### Application for a Non-Material Amendment Following a Grant of Planning Permission

Erection of a first floor side extension to form additional living accommodation. Creation of new access on to Overndale Road.

P21/05688/F

Extension at 147 Overdale Rd - P21/05688/F

SIDE ELEVATION 1:100

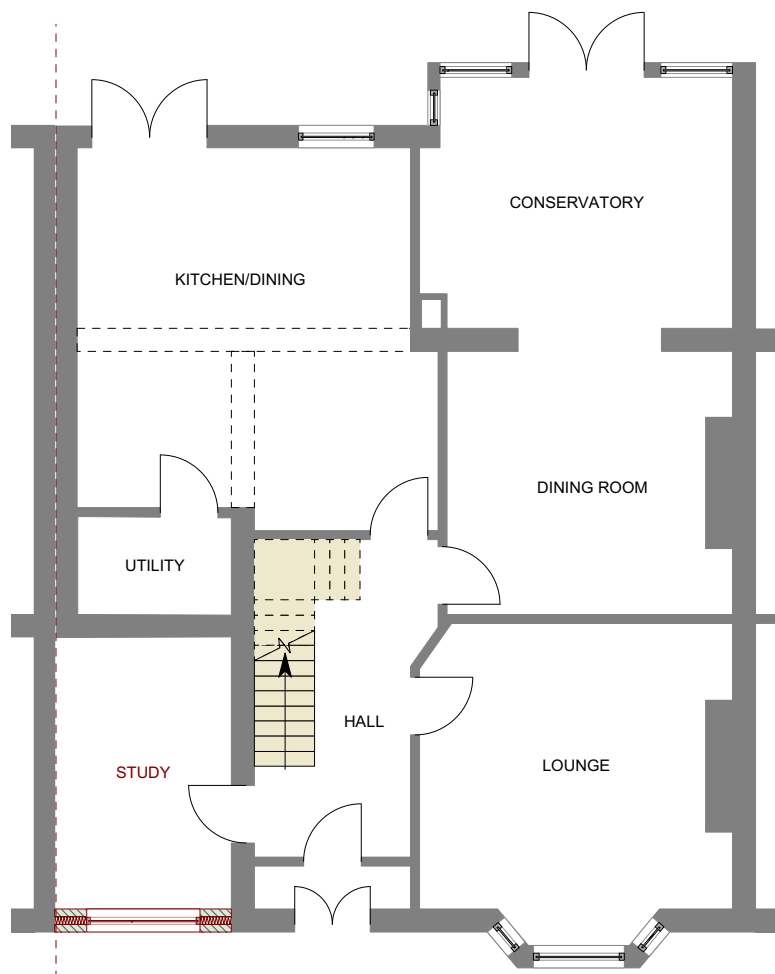
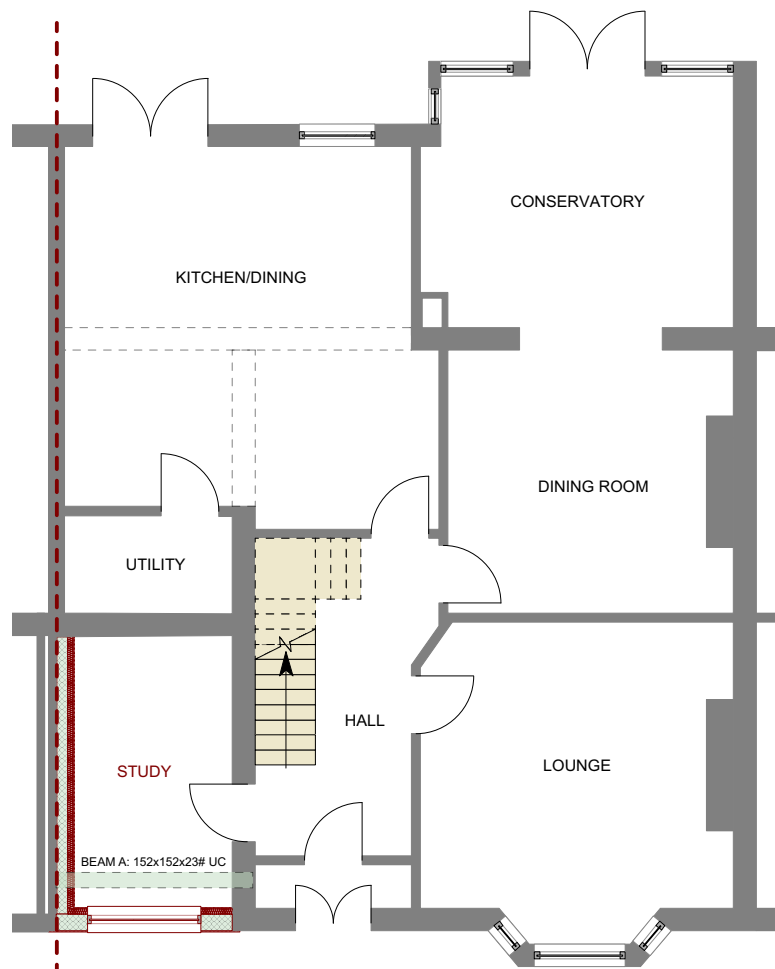
Eaves brought back to building line with a box gutter on the side elevation.

Party wall situation. Changes meant that there is no overhang onto neighbouring land.
